KITTITAS COUNTY COMMUNITY DEVELOPMENT SERVICES

January 24, 2018

RE: *SX-18-00002 Lake Kachess Resort Shoreline Exemption – Request for additional information*

TOPOGRAPHIC SURVEY

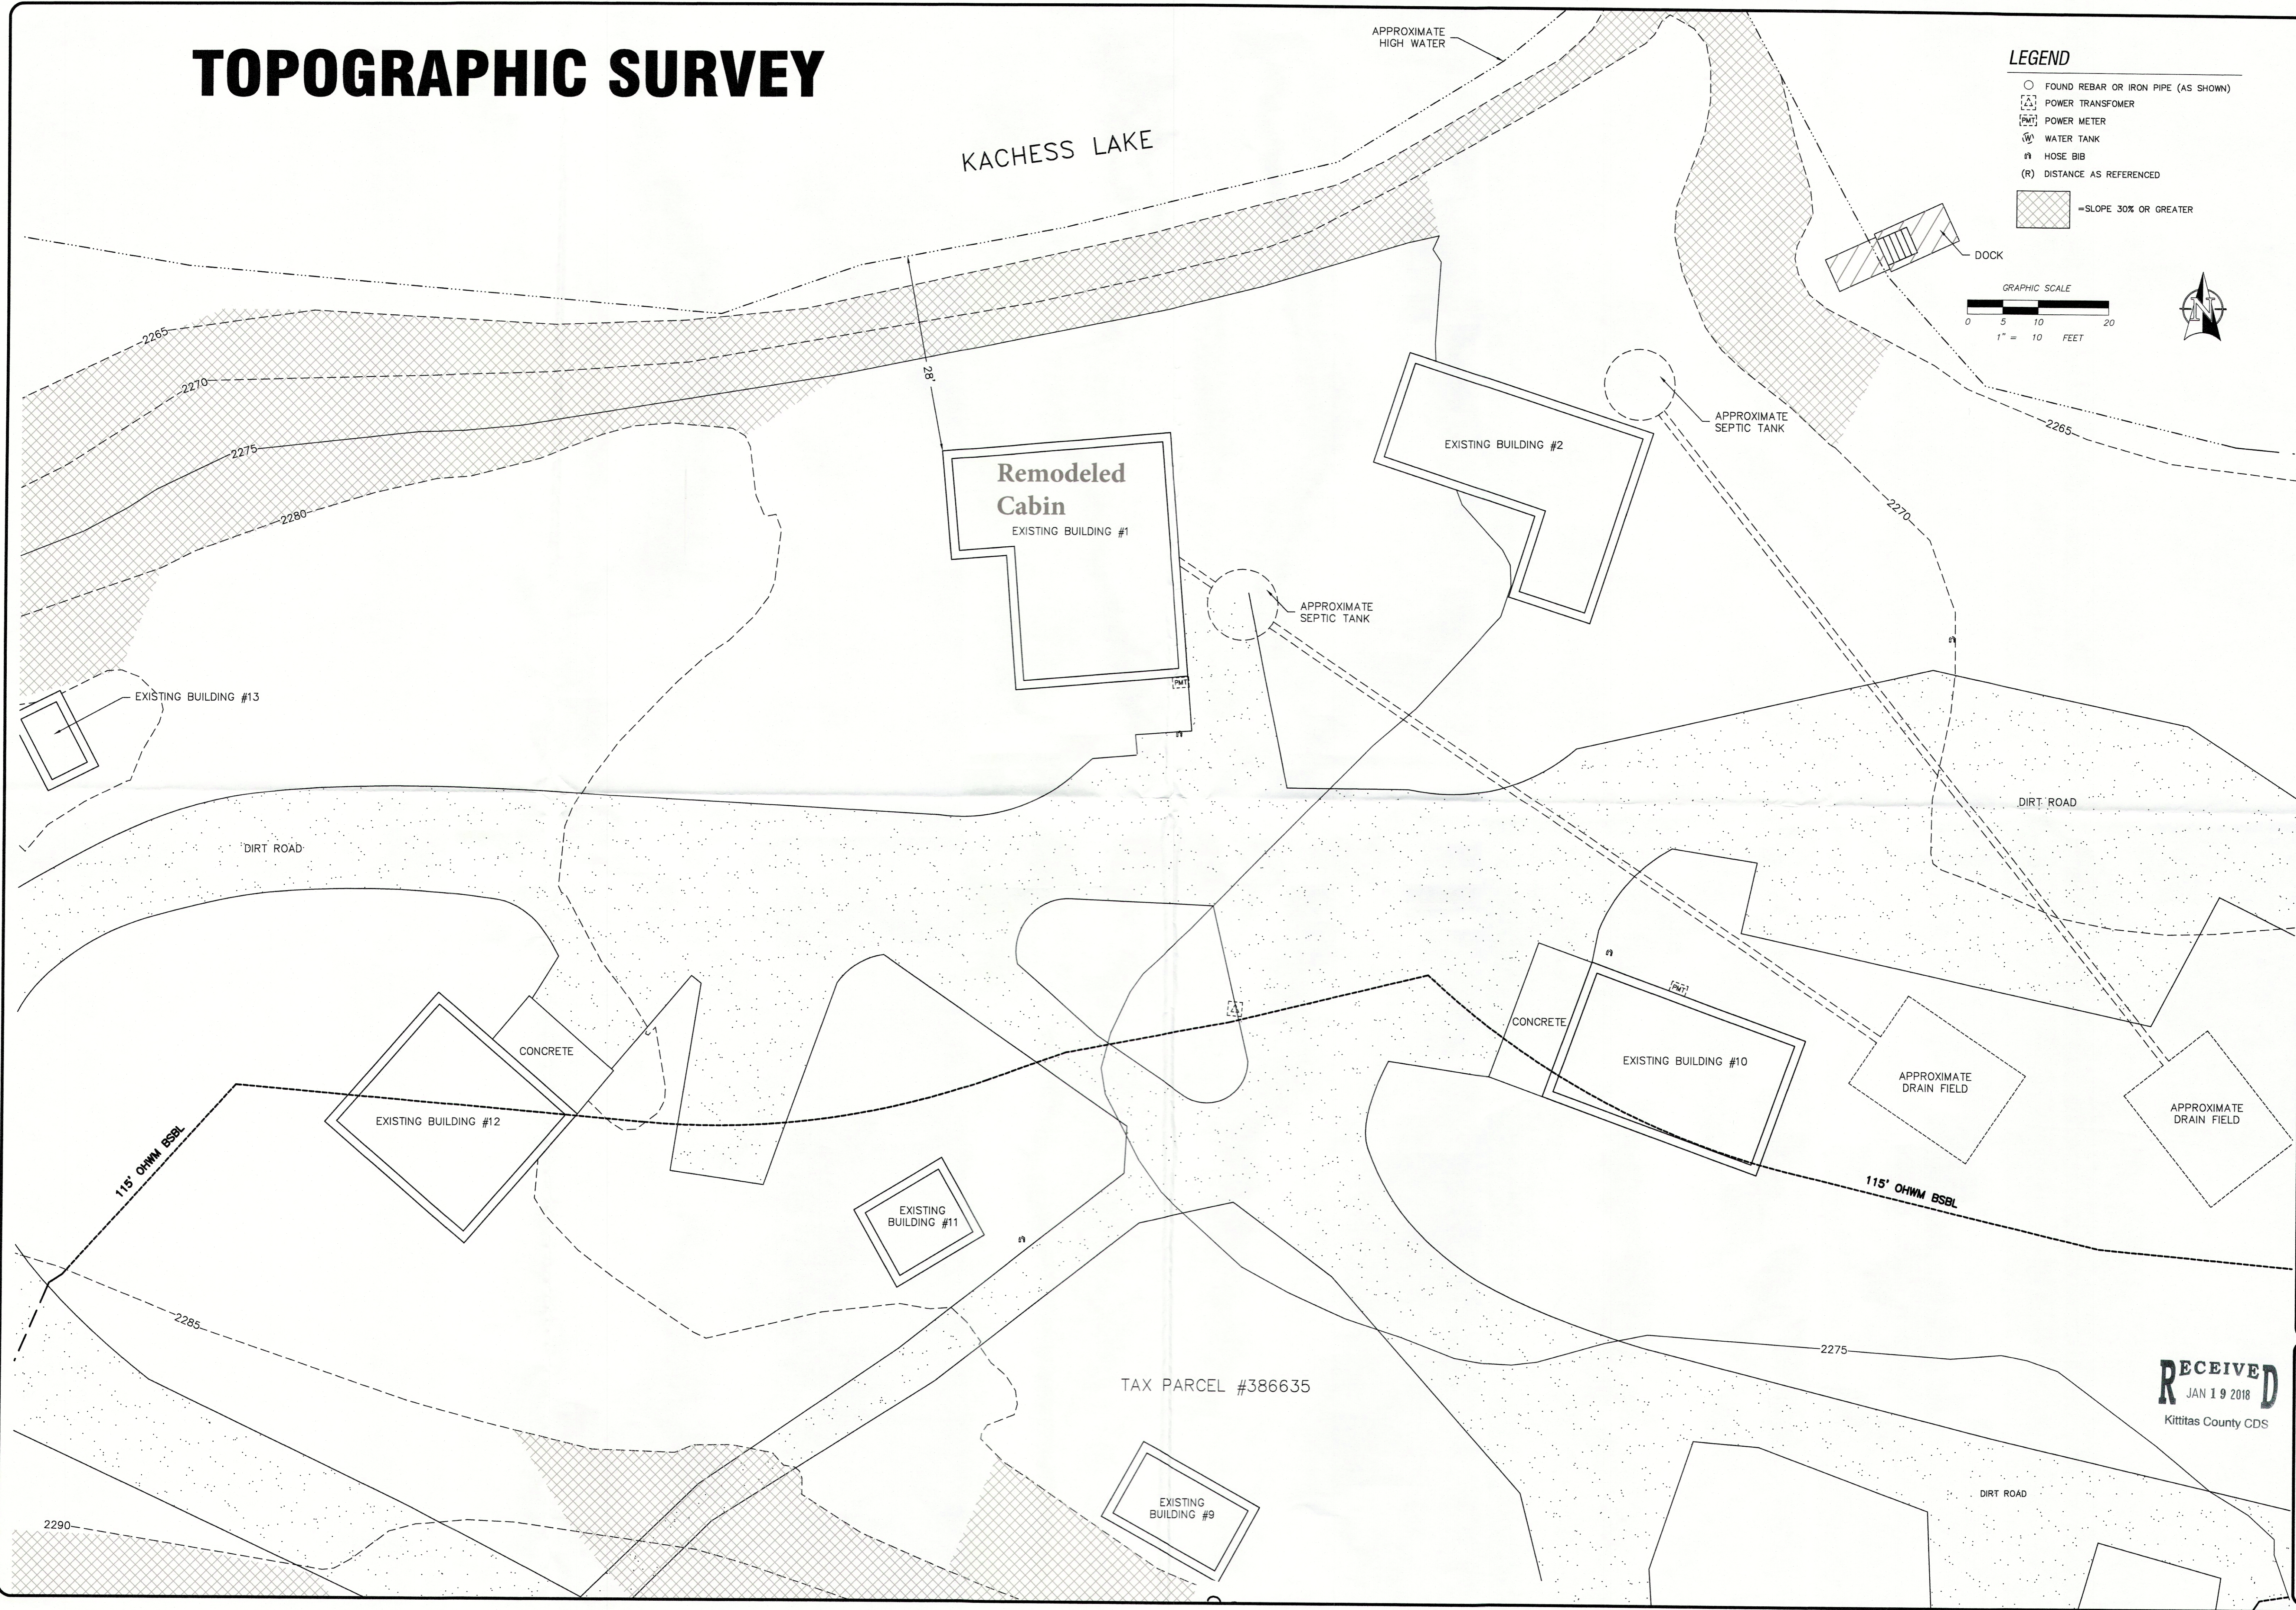
The site plans submitted do not indicate the directional footprint of the addition. Please submit an amended site plan demonstrating the original footprint and the exact location of any additions. Any expansion of a residence within this distance from the shoreline must take place landward of the existing structure footprint. I have attached an example with this letter. Expansion in any other direction will not qualify for an exemption.
